Arun District Council
Arun Civic Centre
Maltravers Road
Littlehampton
West Sussex BN17 5LF
Planning & Building Control General Enquiries
Tel: (01903) 737756 Fax: (01903) 730442
Dx: 57406 Littlehampton
Minicom: 01903 732765
e-mail: planning@arun.gov.uk
website: www.arun.gov.uk/planning

Application No: FG/2/21/HH
Site Address: 3 Sea Drive Ferring BN12 5HD
Description of works: Erection of a detached garage.

Thank you for your internet representation made on 26th January 2021 which has been recorded as an objection with the comments as follows:

SITE PLAN 1:500 @ A4

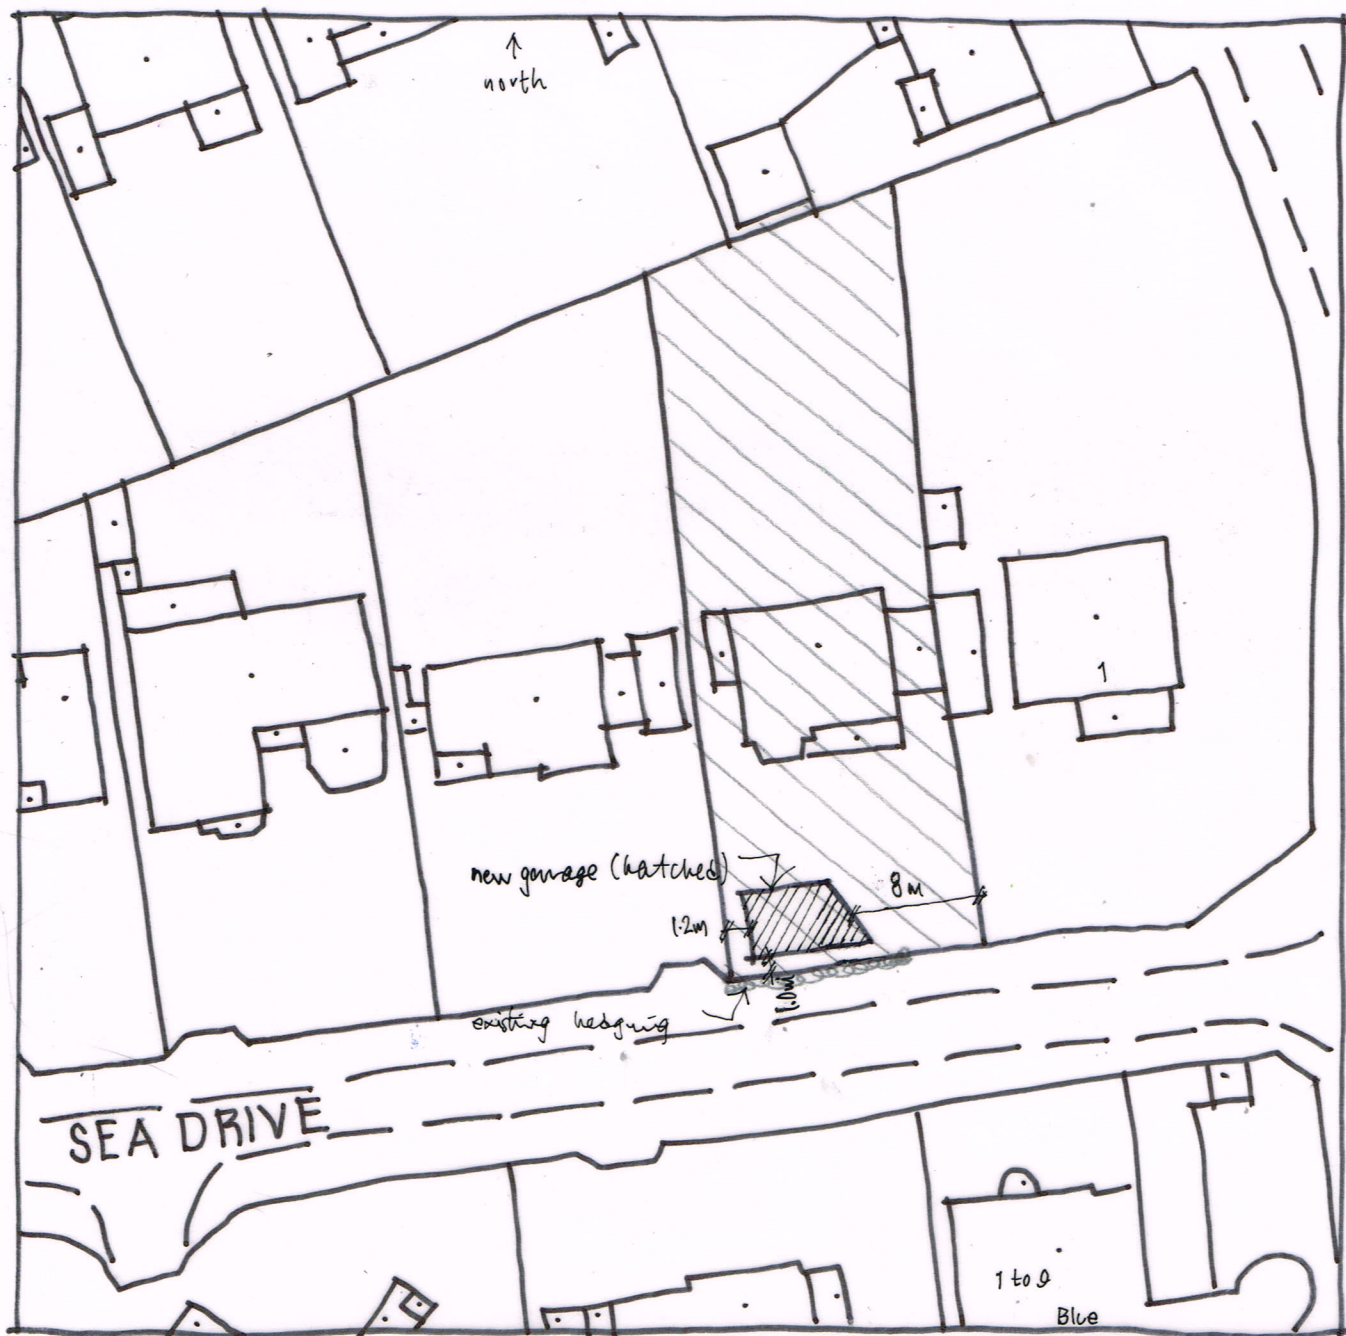
The proposed garage is far in front of the building line in our drive. It would be an eyesore. Although it would at present be hidden by the existing hedge, the hedge might not always be there. I strongly object. Also, I do not see any posting of notice of this planning application in front of the property. Thank you.
